Your ref:	Wigmore Street Cond 5(a) (b)	<b>Please reply to:</b>	<b>Mr Joshua Wilson</b>
Our ref:	23/07464/ADFULL	Tel No:	
		Fee Queries:	0207 641 6500;
		Email:	planningreception@westminster.gov.uk;
Damian McGeary Myco Contracts Ltd, Godliman House, 21 Godliman Street London EC4V 5BD United Kingdom		<b>Incomplete Applications</b> Town Planning & Building Control City of Westminster PO Box 732 Redhill, RH1 9FL	
		13 November 2023

**Address: 18 Wigmore Street, London, W1U 2RG,**

**Proposal: Detailed drawings of new metal railings and gates to the front lightwell and new shopfronts pursuant to Condition 5 (A) and (B) of planning permission dated 19th April 2021 (RN:20/04541/FULL)**

DRAWING NAME
240441-PUR-00-XX-DR-A-3028

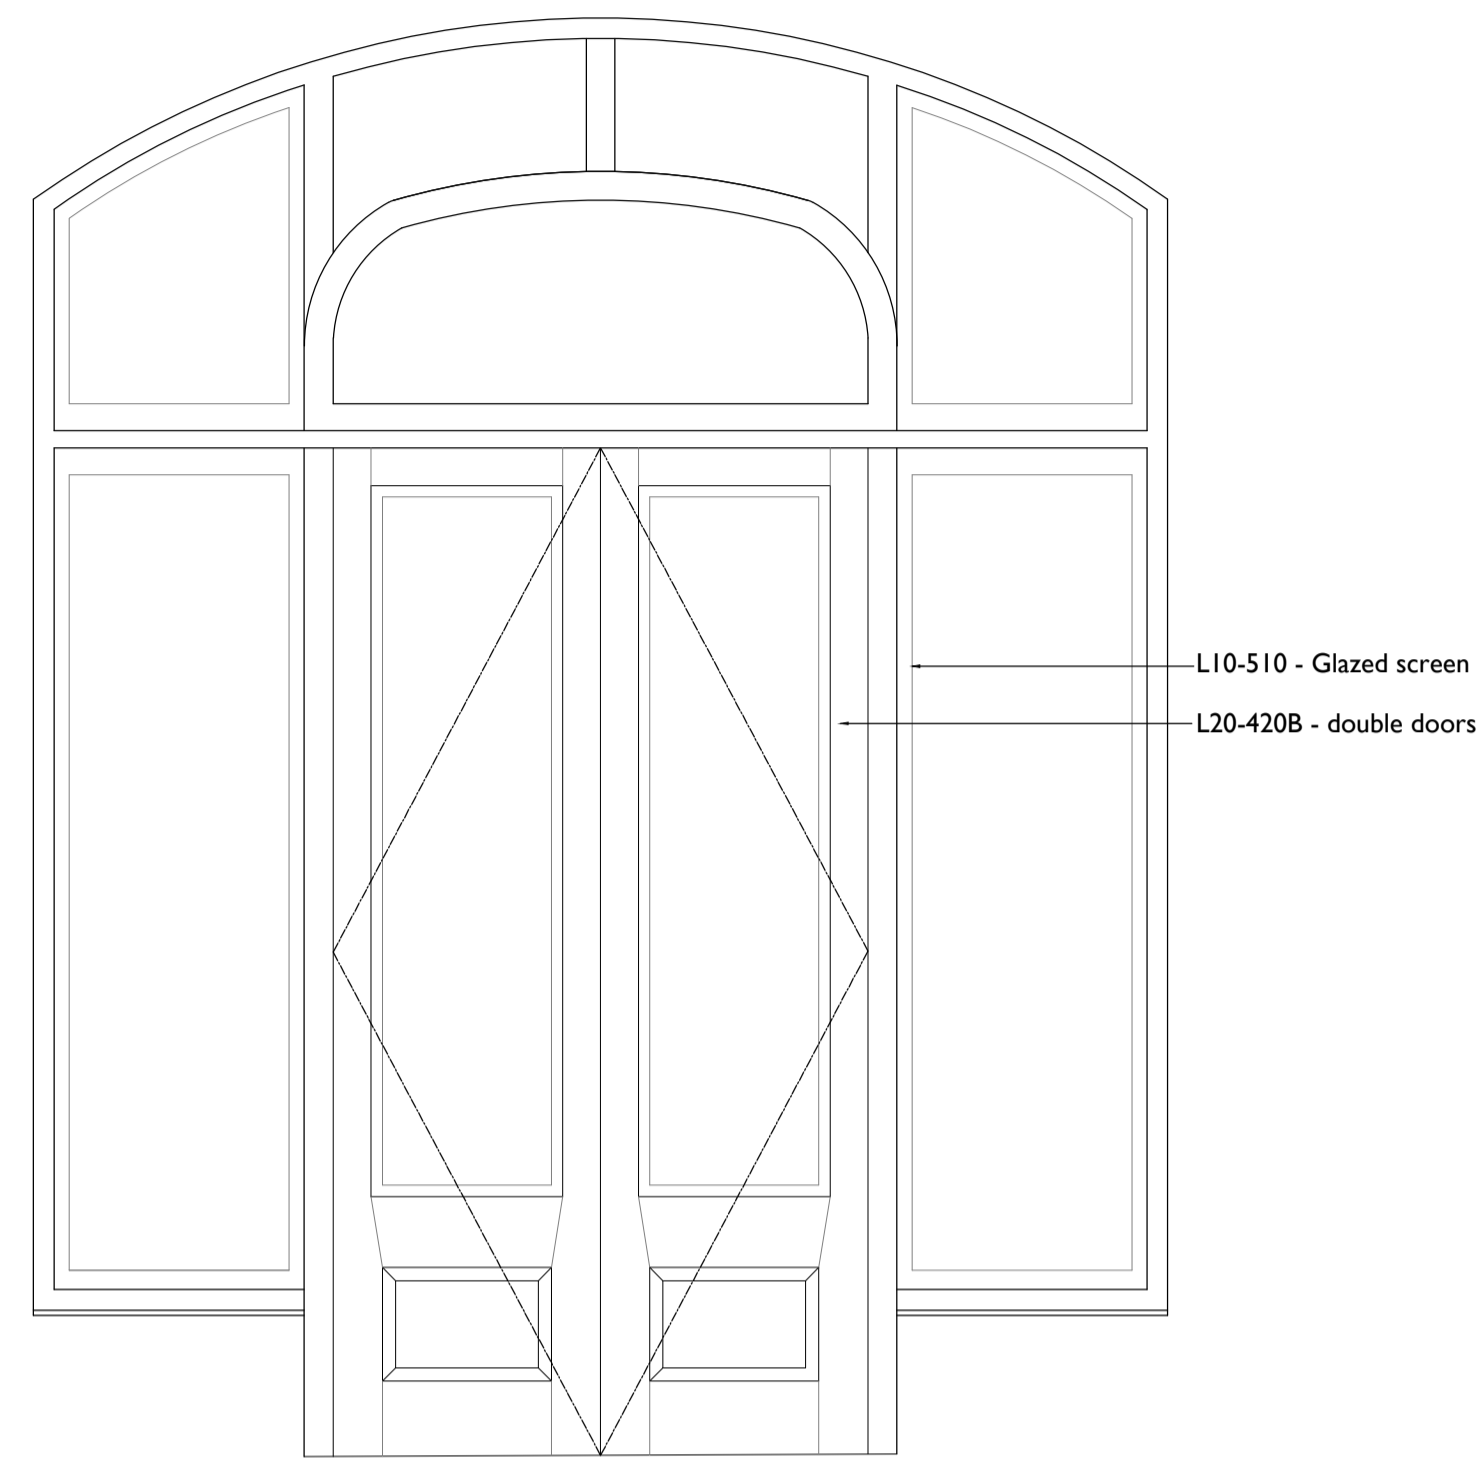
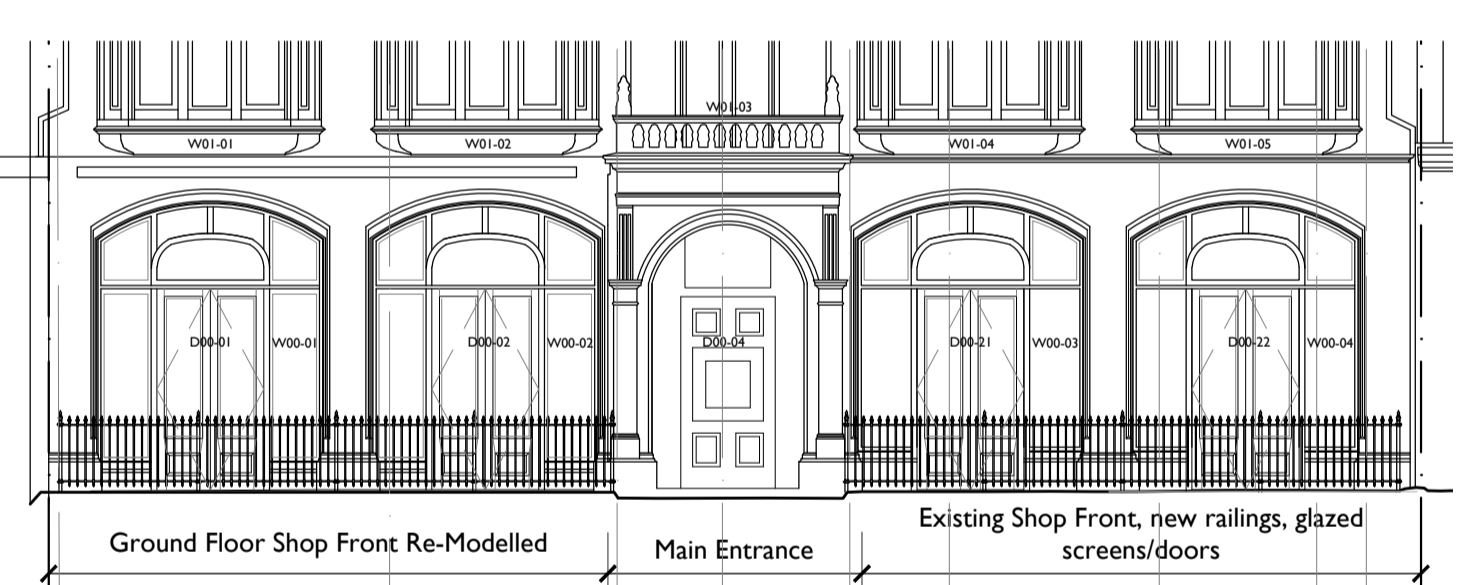
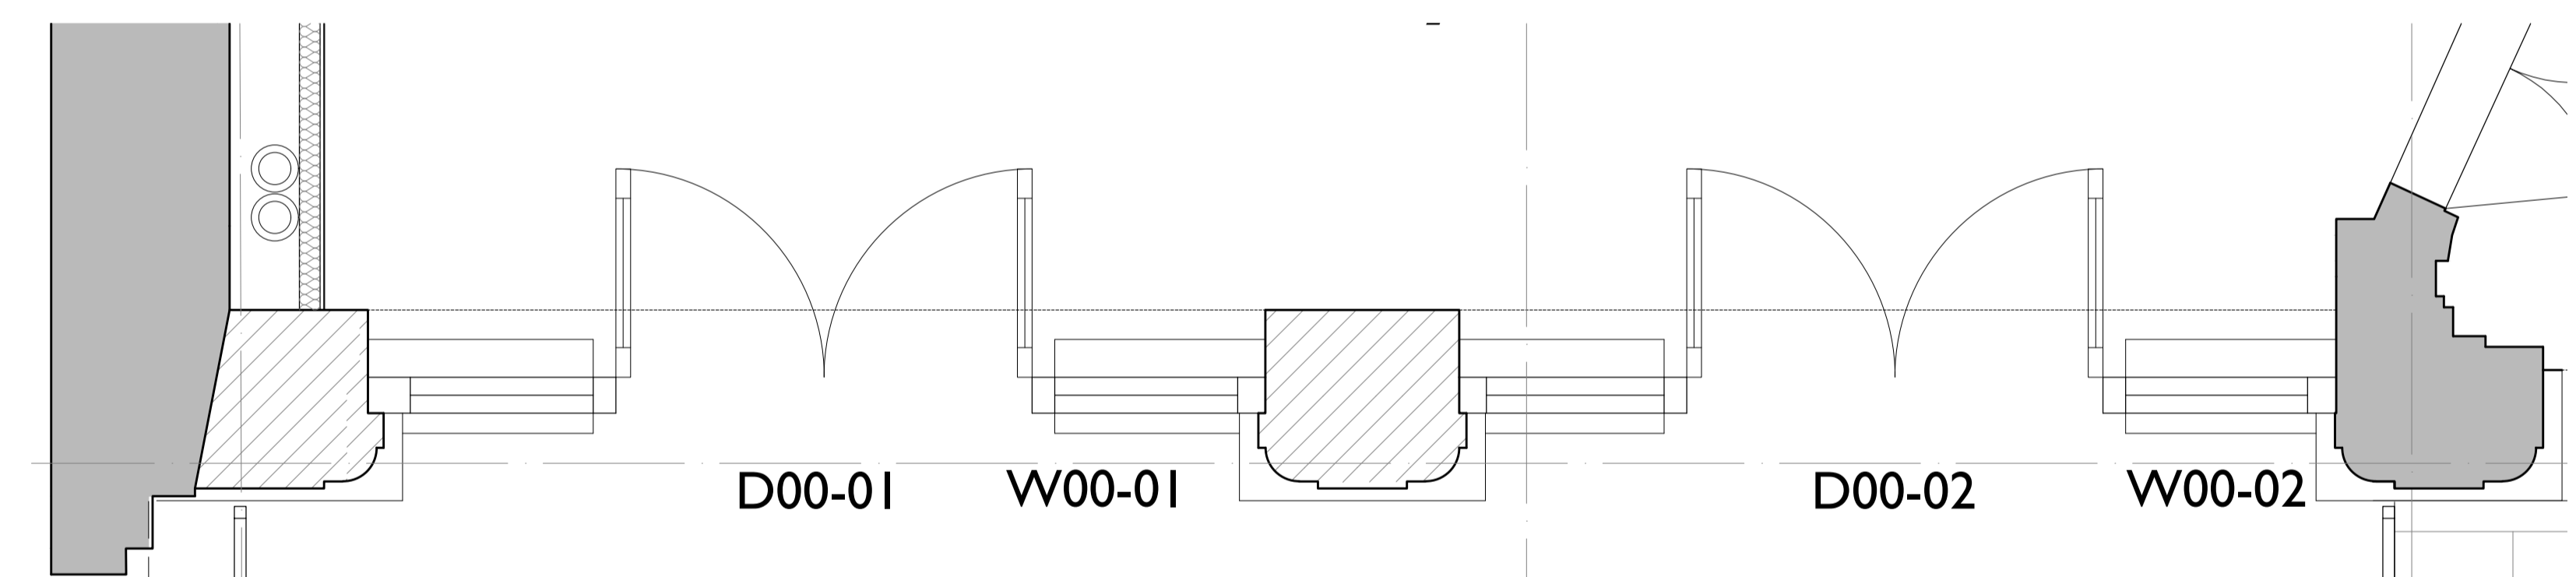
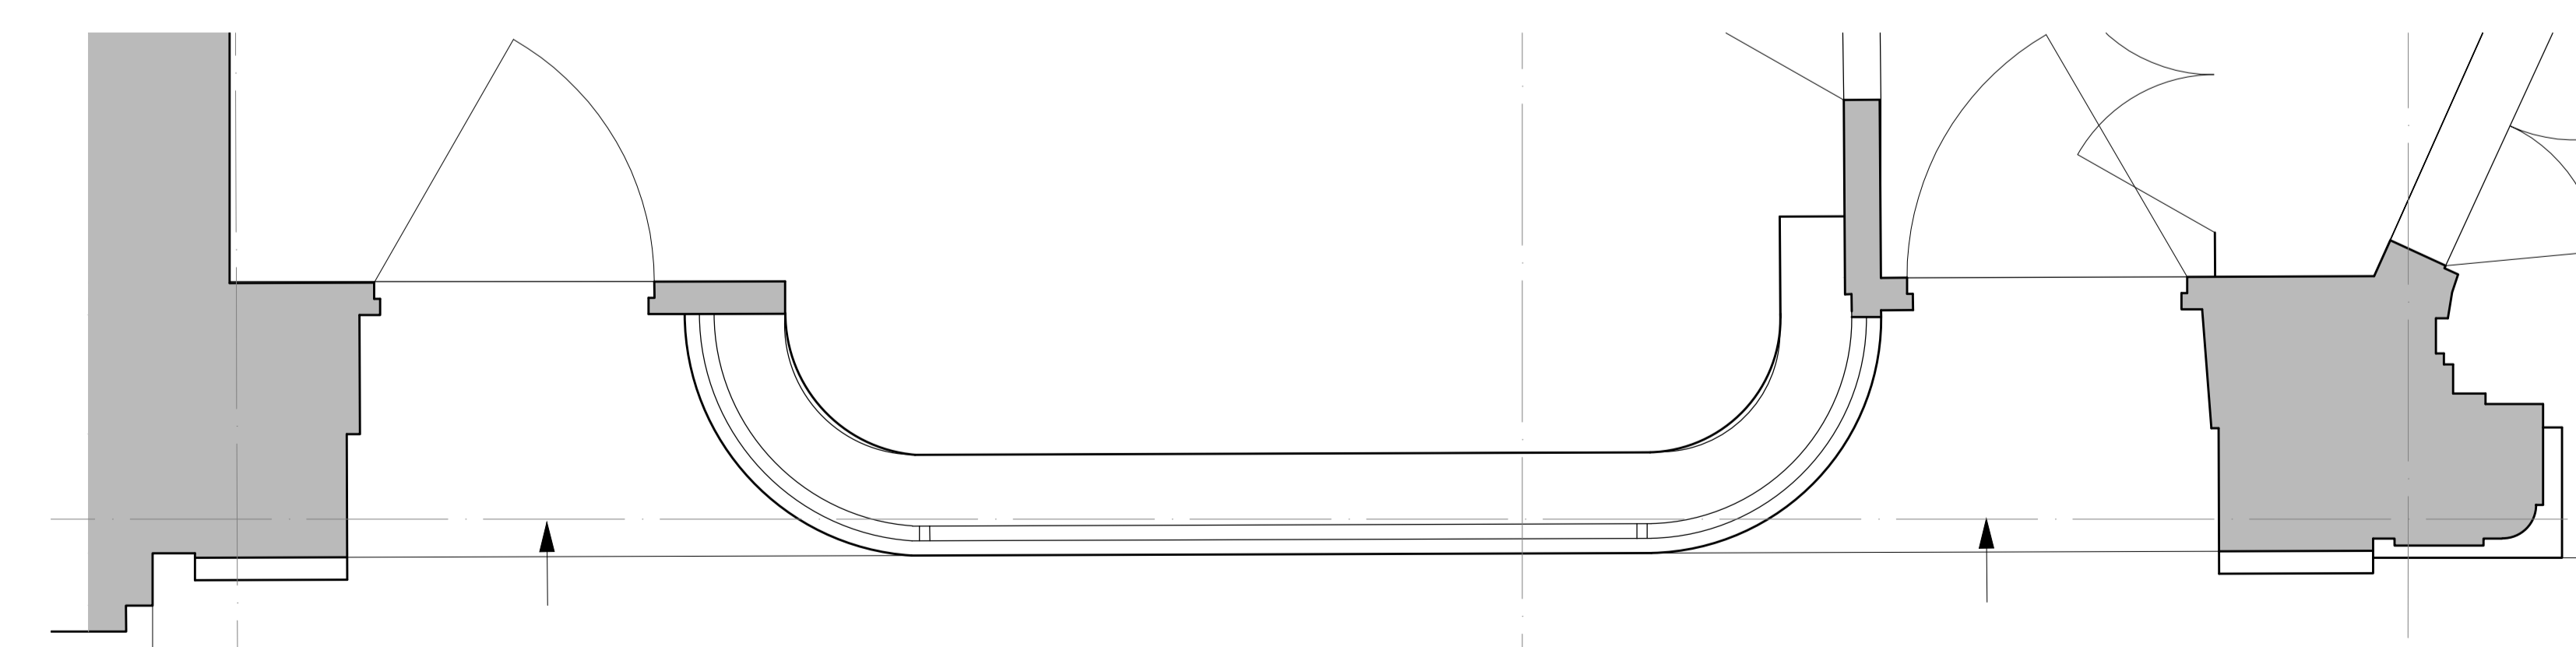
- The condition requires full details of all windows, doors and railings, showing interfaces with existing fabric and showing them to the scales required by the existing condition.

- 2 Some or all of the drawings submitted with your application do not include a scale bar, please amend the drawings to ensure all drawings include a scale bar.
